Hillpointe Apartments Site Development Plan

To: Jen Uhler, Project Manager
For: Blaine Perkins, HR Green, Inc.
Project: Hillpointe Apartments Site Development Plan
EA Number: EA2593
File Number: PPR2613
Date: June 1, 2026

Subject: Fire Department Site Development Plan Review Comments – Hillpointe Apartments (PPR2613)

SITE DEVELOPMENT PLAN
FIRE PROTECTION PLAN

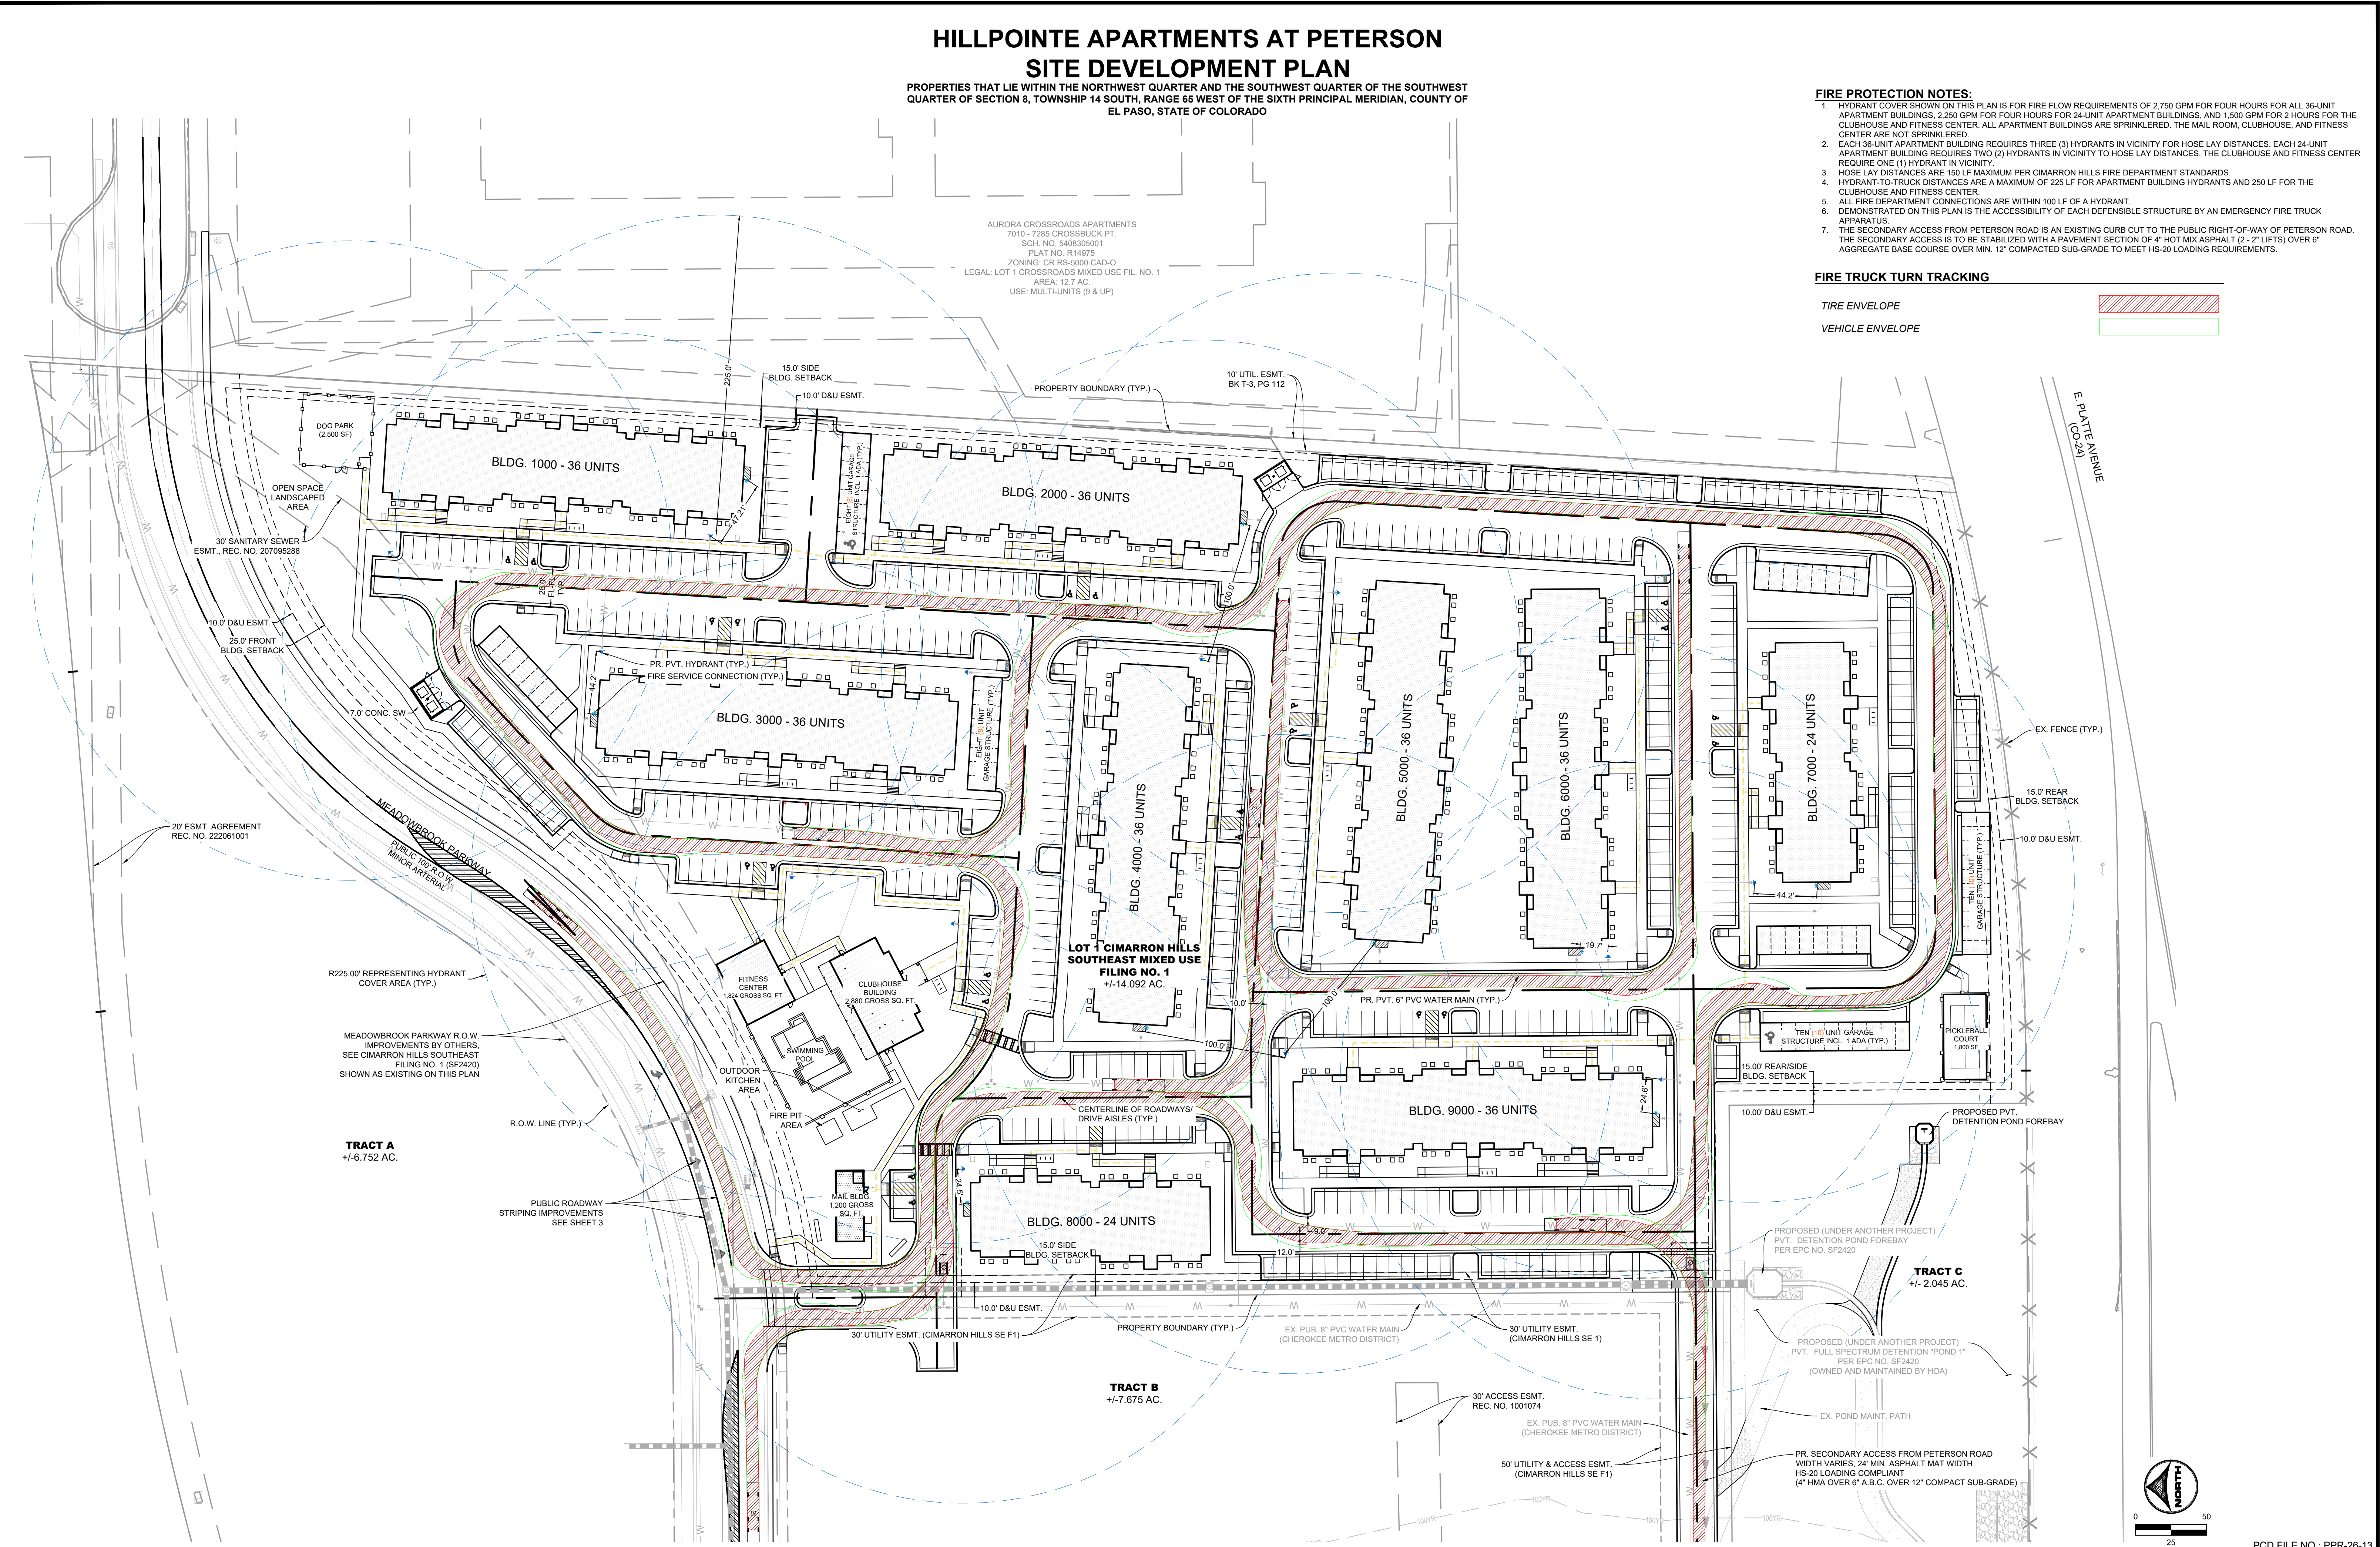
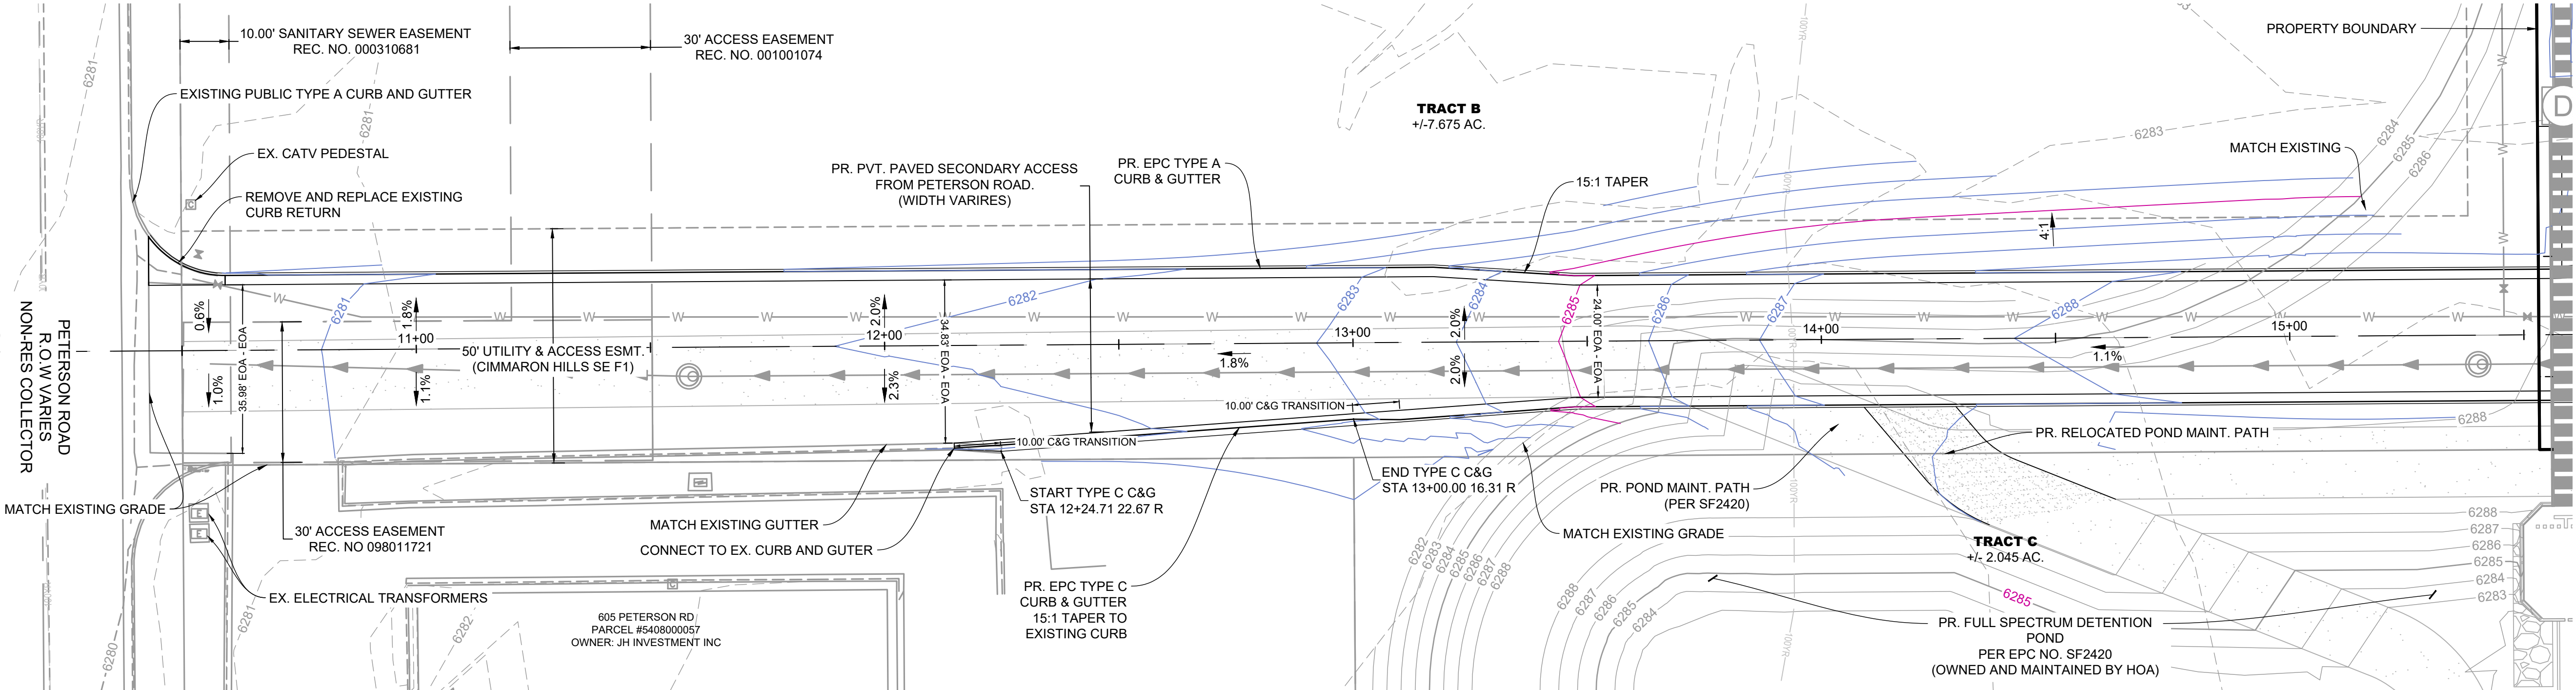
Pursuant to IFC Sections 503 and 503.2.4, fire apparatus access roads shall be designed and maintained to accommodate the turning movements and operational requirements of the fire apparatus serving the development. CHFD requests verification that all internal roadways, intersections, parking lot drive aisles, fire lanes, and turnaround areas can accommodate an aerial ladder apparatus, including consideration of apparatus length, wheelbase, overhang, steering geometry, and operational setup requirements.

- Narrow roadway widths
- Insufficient turning radii
- Tight corner geometry
- Vertical clearance limitations
- Landscaping encroachments
- Parking conflicts
- Utility or site obstructions

Fire apparatus access roads shall provide turning geometry sufficient to accommodate responding fire apparatus. As a design reference, CHFD recommends evaluation of the following minimum dimensions:

- Inside Turning Radius: 25 feet minimum
- Outside Turning Radius: 42 feet minimum

Where aerial apparatus access is required, larger turning radii may be necessary based on apparatus specifications and site conditions.

Dead-end fire apparatus access roads exceeding 150 feet in length shall comply with IFC Appendix D, Section D103.

Pursuant to IFC Section 1207.5, EV charging equipment subject to vehicle impact shall be protected from physical damage by approved means, including but not limited to bollards, wheel stops, curbs, landscape islands, or equivalent protection. Alternatively, equipment may be installed outside the normal vehicle path of travel where demonstrated to be protected by location.

EV charging equipment, pedestals, transformers, cabinets, and associated infrastructure shall not obstruct or reduce required fire apparatus access road widths, fire lanes, fire hydrants, fire department connections (FDCs), means of egress, emergency access points, or required electrical working clearances.

Site plans shall clearly identify the location of all EV charging equipment and demonstrate compliance with applicable fire and electrical code requirements, including the proposed method of impact protection where required.
